**Subject:** Rezoning Petition Review

**Rezoning Petition #:** 22-052

**Location of Property:** Approximately 1.9 acres located on the north side of Tuckaseegee Rd, west of Toddville Rd and north of I-85

SHEET NO.
RZ-1

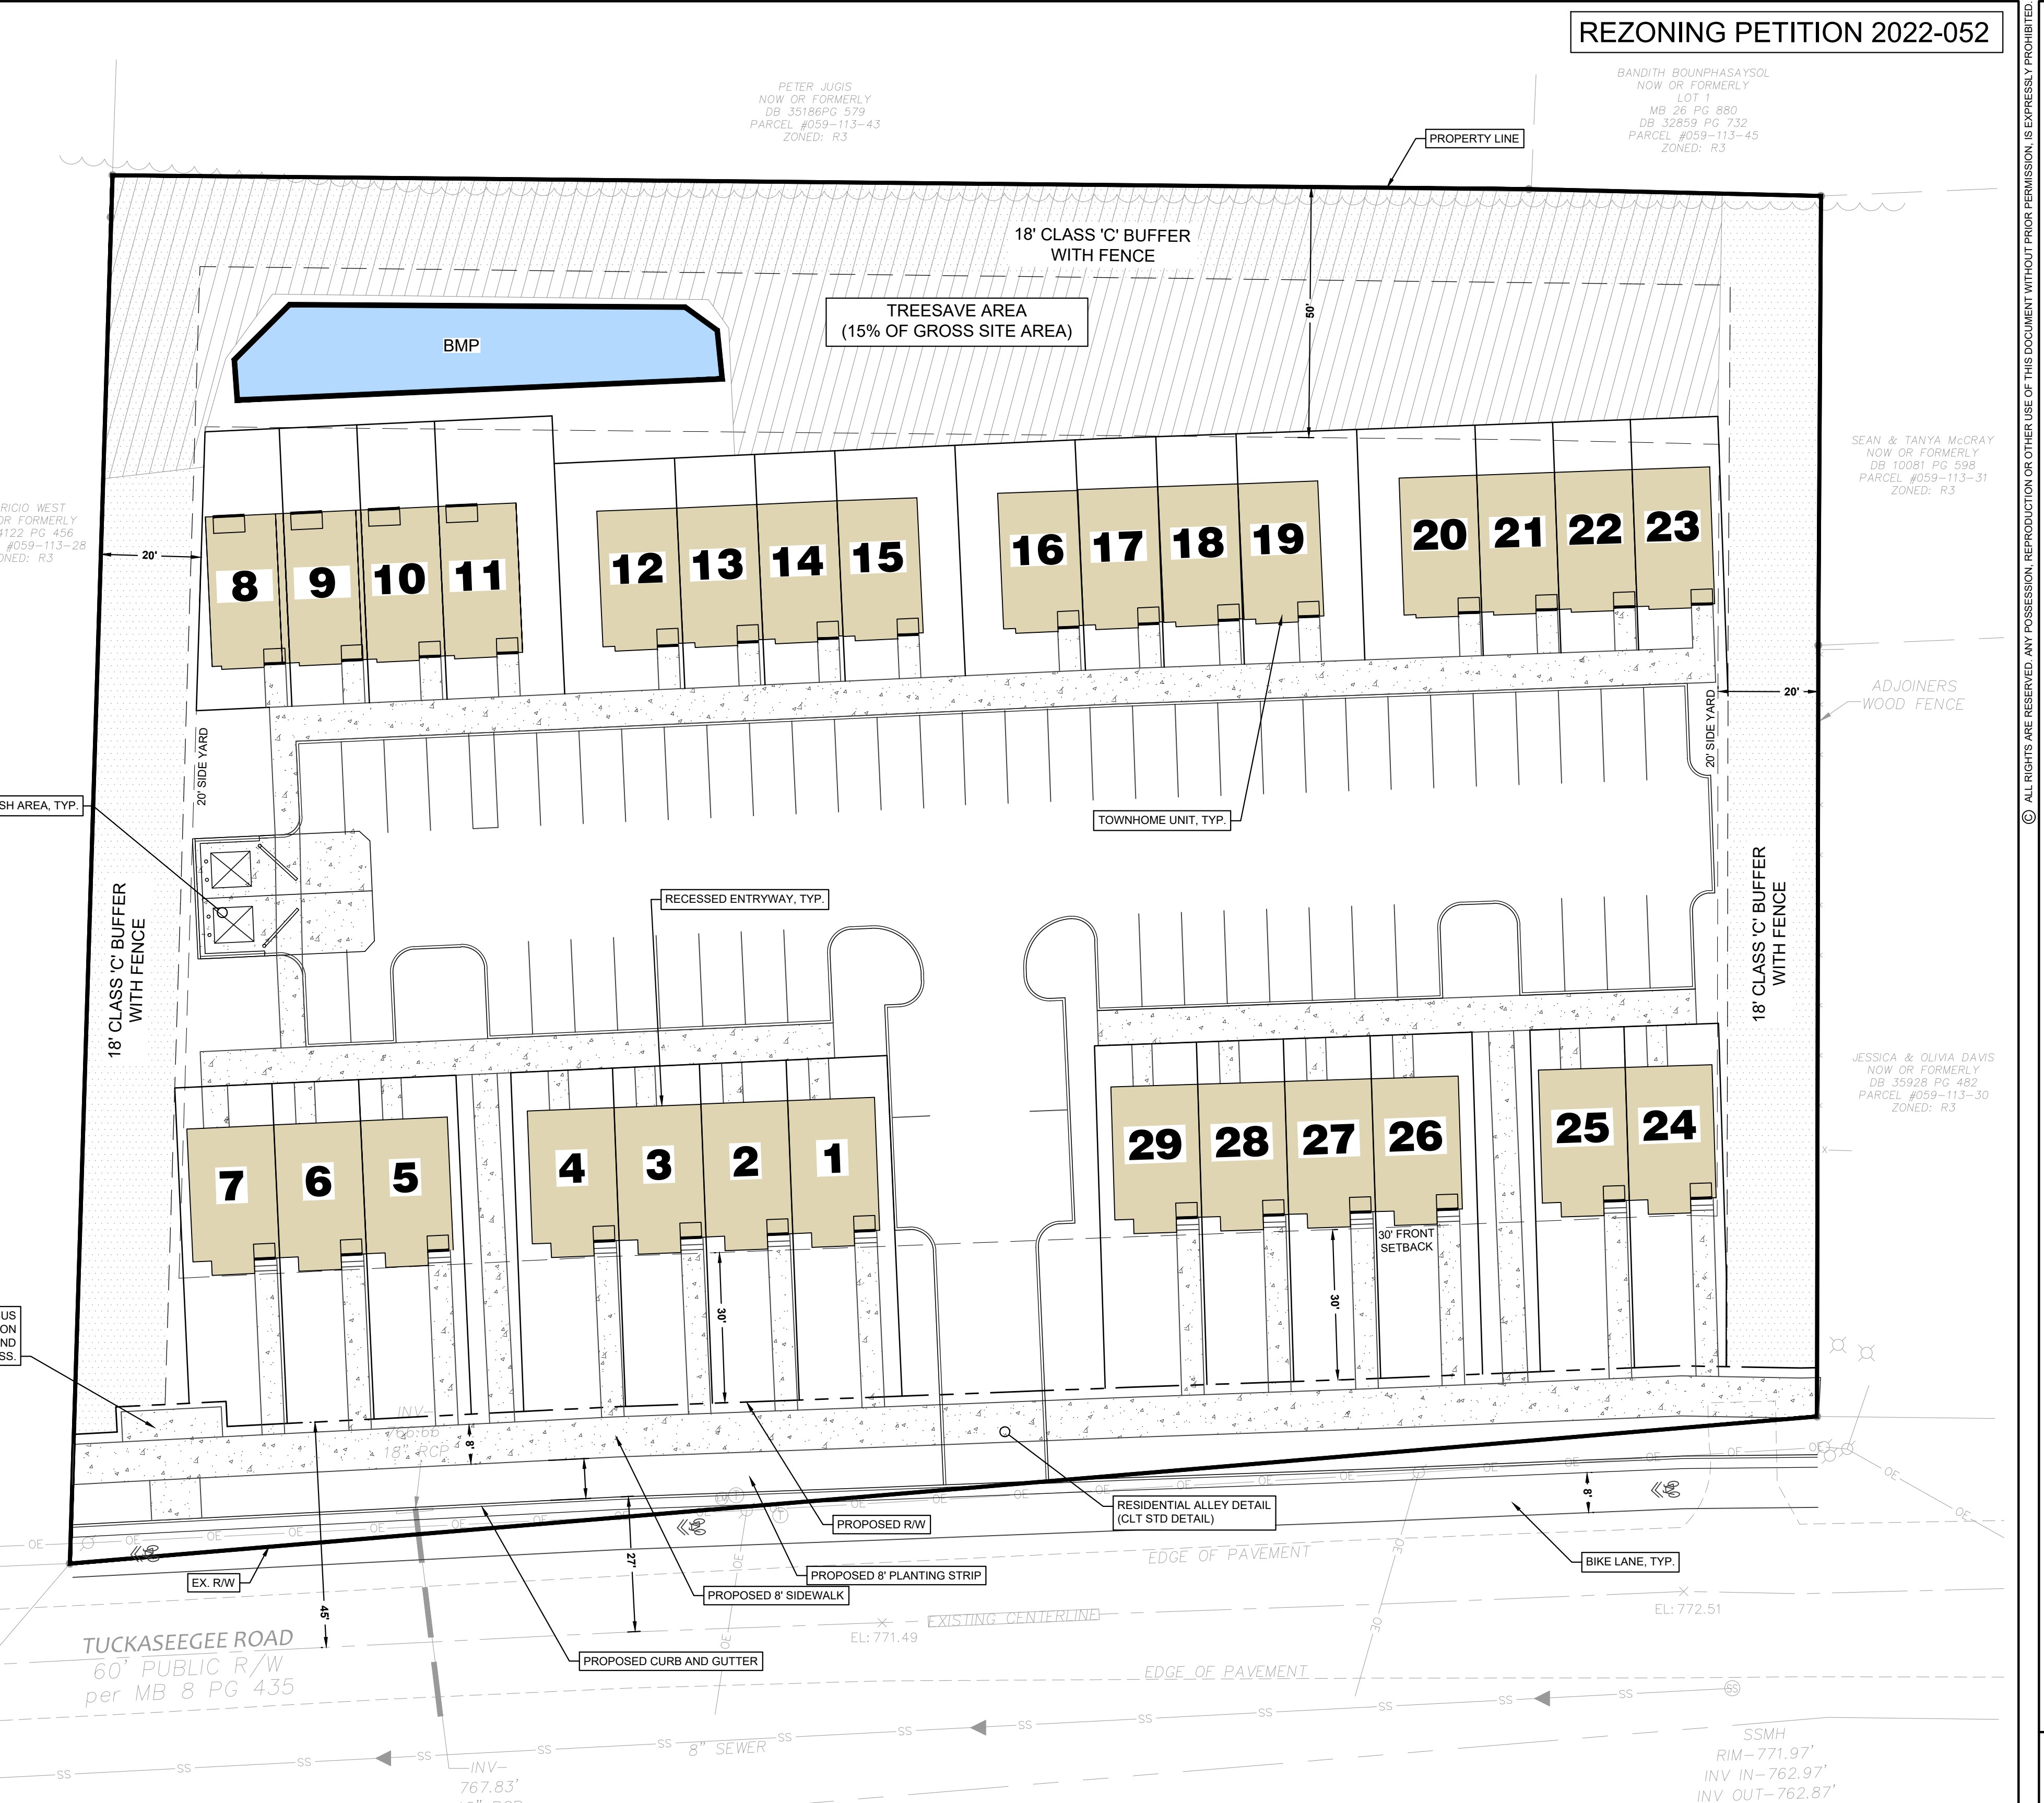
The proposed rezoning plan sheet indicates a proposed location for storm water management. Please include the following notes on the plan sheet under "Environmental Features": *The location, size, and type of storm water management systems depicted on the Rezoning Plan are subject to review and approval as part of the full development plan submittal and are not implicitly approved with this rezoning. Adjustments may be necessary in order to accommodate actual storm water treatment requirements and natural site discharge points.*

**This property drains to Paw Creek, which is an impaired/degraded stream, and may contribute to downstream flooding. This project has the opportunity to mitigate future impacts to this stream, therefore, Storm Water recommends placing the following notes on the plan:**

For defined watersheds greater than 12% built-upon area (BUA), construct water quality stormwater control measures (SCMs) designed for the runoff generated from the first 1-inch of rainfall for all new and redeveloped BUA associated with the project. SCMs must be designed and constructed in accordance with the Charlotte-Mecklenburg BMP Design Manual.

For defined watersheds greater than 12% built-upon area, control the entire volume for the 1-year, 24-hour storm for all new and redeveloped BUA associated with the project. Runoff volume drawdown time shall be in accordance with the Charlotte-Mecklenburg BMP Design Manual.

For residential projects with greater than 12% BUA, control the peak to not exceed the predevelopment runoff rates for the 10-year and 25-year, 6-hour storms or perform a downstream analysis to determine whether peak control is needed, and if so, for what level of storm frequency.

**This property drains to Paw Creek, which is an impaired/degraded stream, and may contribute to downstream flooding. This project has the opportunity to mitigate future impacts to this stream, therefore, Storm Water recommends placing the following notes on the plan:**

For defined watersheds greater than 12% built-upon area (BUA), construct water quality stormwater control measures (SCMs) designed for the runoff generated from the first 1-inch of rainfall for all new and redeveloped BUA associated with the project. SCMs must be designed and constructed in accordance with the Charlotte-Mecklenburg BMP Design Manual.

For defined watersheds greater than 12% built-upon area, control the entire volume for the 1-year, 24-hour storm for all new and redeveloped BUA associated with the project. Runoff volume drawdown time shall be in accordance with the Charlotte-Mecklenburg BMP Design Manual.

For residential projects with greater than 12% BUA, control the peak to not exceed the predevelopment runoff rates for the 10-year and 25-year, 6-hour storms or perform a downstream analysis to determine whether peak control is needed, and if so, for what level of storm frequency.
